# COUNTY COUNCIL'S RESPONSE TO CONSULTATION ON THE FOLLOWING DEVELOPMENT PROPOSAL

**Application No:** 17/02557/REM

**Proposal:** Reserved matters to 16/02586/OUT - Erection of hotel and associated works

**Location:** Hotel Bicester Gateway Business Park, Wendlebury Road, Chesterton, Bicester OX25 2BX.

DIAGRAM 1 - VEHICULAR TRACKING

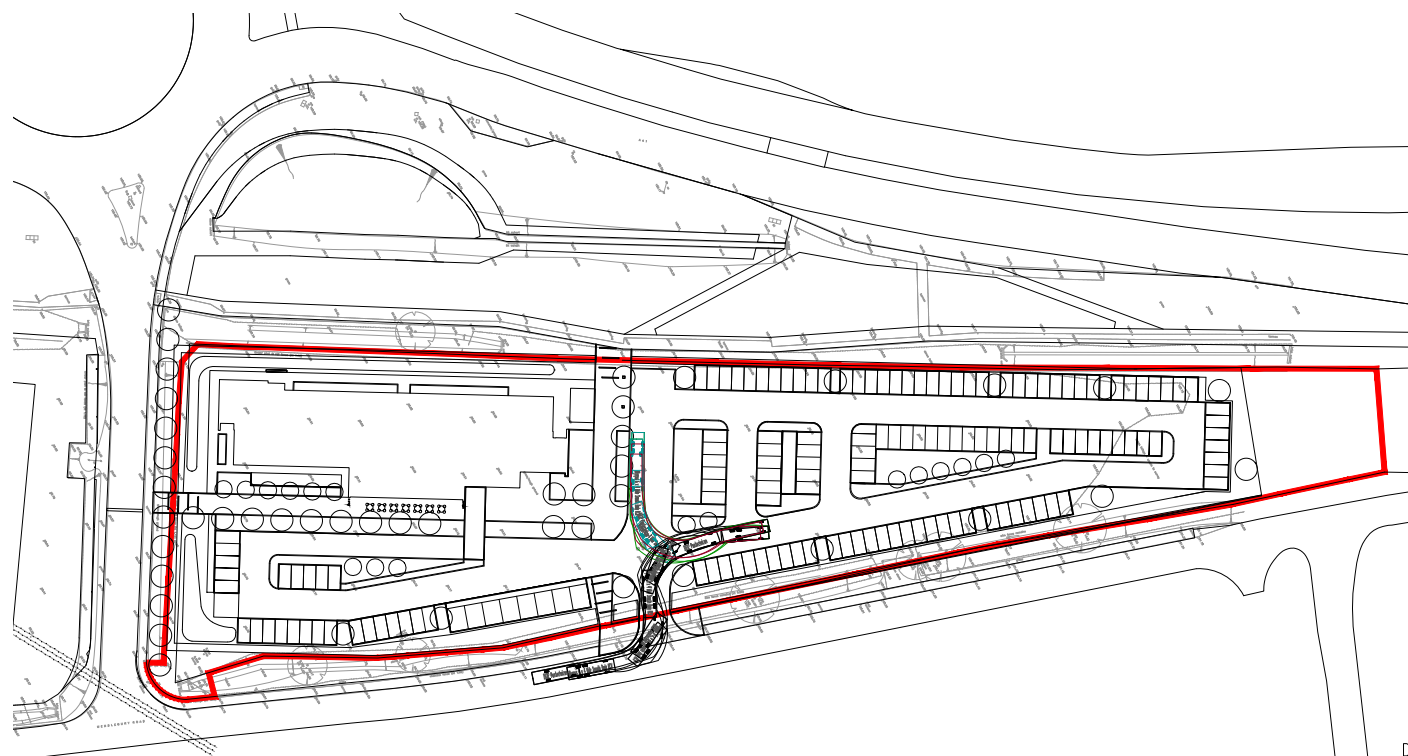
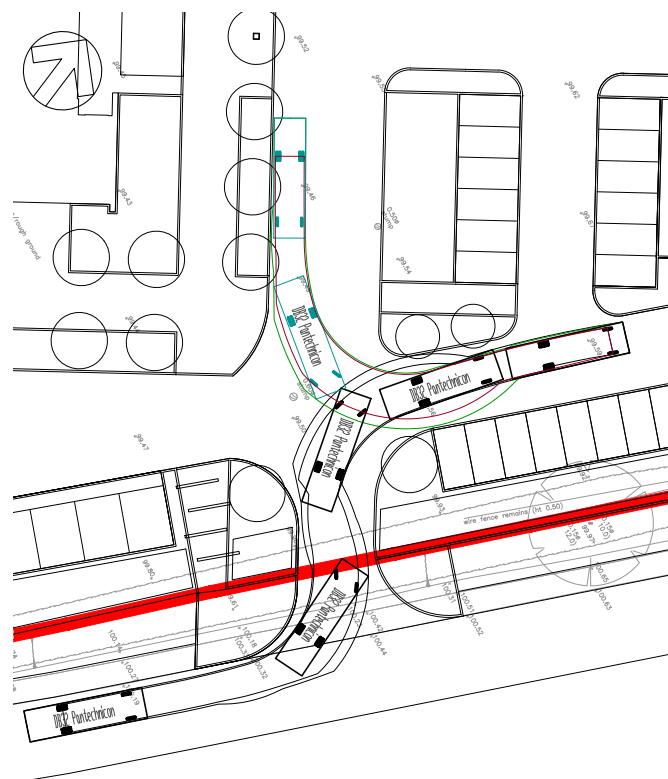
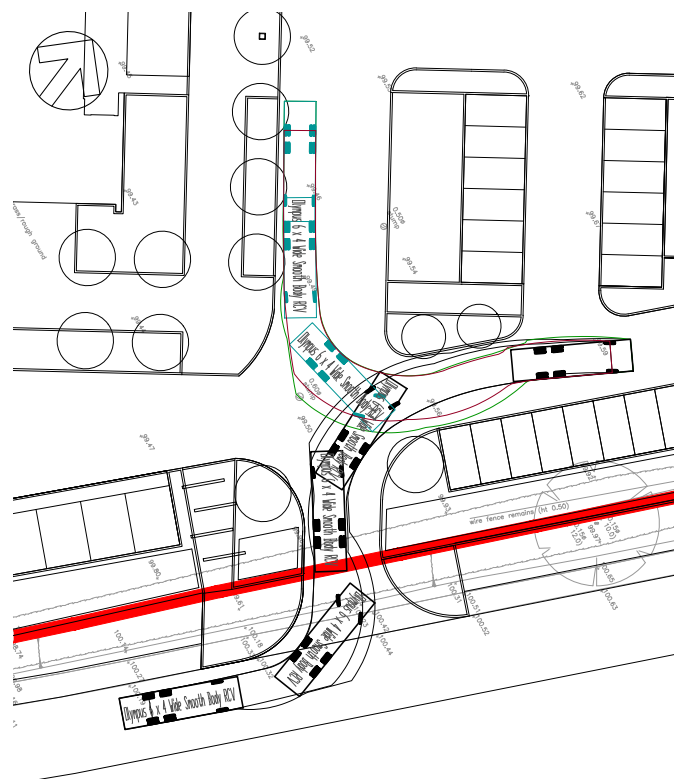
One parking space per bedroom is shown, which is acceptable, and the proportion of disabled parking spaces is acceptable. The layout of the car park is suitable, except that I would query the 'Pantehnicon' vehicle assumed to make deliveries. Other hotel chains have specified larger vehicles, including max articulated lorries. The tracking within the car park and where vehicles turn in and out of Wendlebury Road should be re-done with this type of vehicle, and localised widening of Wendlebury Road may be required.

DIAGRAM 4 - VISIBILITY SPLAYS

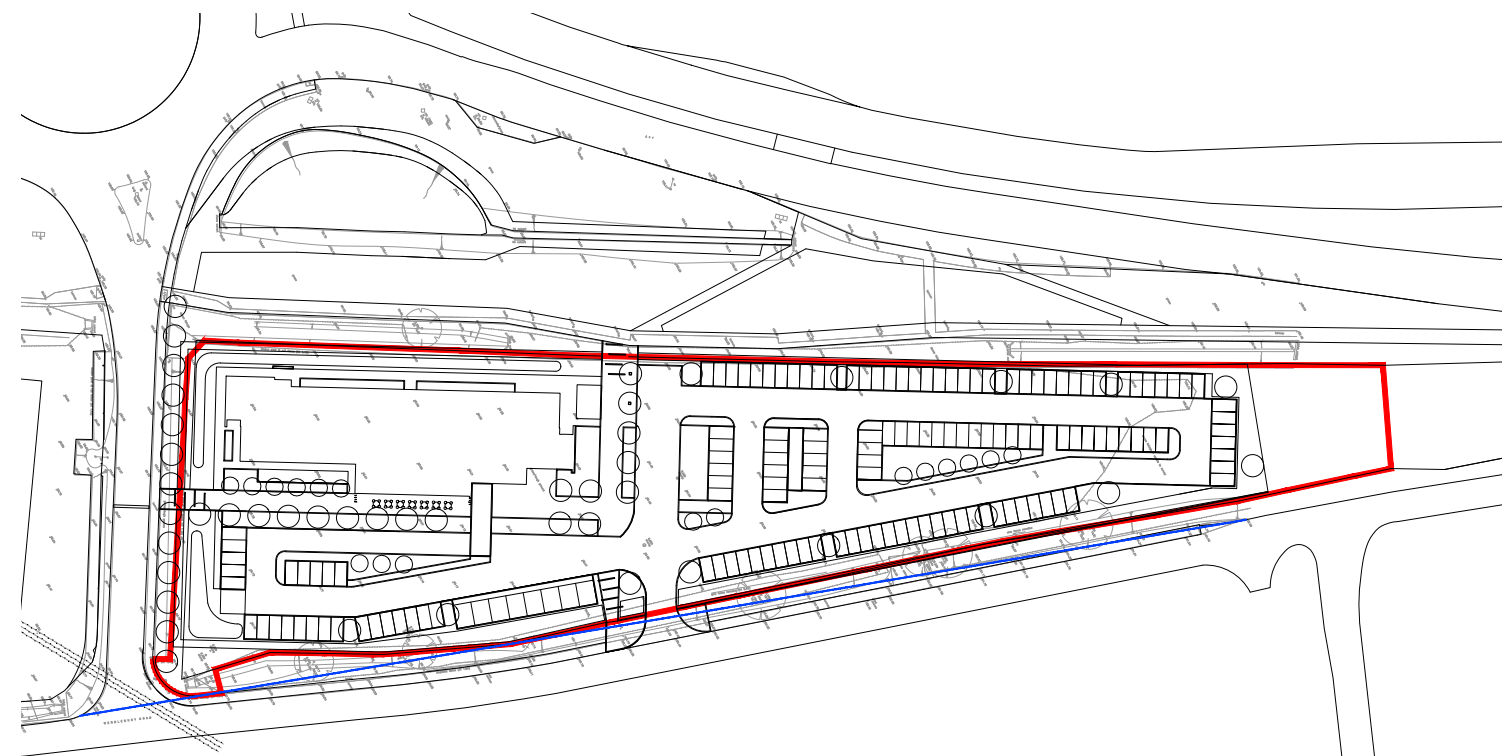
- Hedge proposed to be retained is in the visibility splay required for the vehicular access
- Cycle parking – stands are too close together.
- Vehicle tracking for larger delivery vehicle required

The main vehicular access is on to Wendlebury Road, as indicated in the Outline planning permission. The visibility splay to the south crosses the hedge line and requires removal of part of the hedge. The plan showing vegetation to be retained shows the hedge as being retained. This is not acceptable and will need to be revised. The vis splay will need to be cleared and any part of it within the site will need to be dedicated as highway. Without this, OCC will not be able to issue a S278 agreement for the access bellmouth. The applicant will need to demonstrate title right up to the highway boundary.
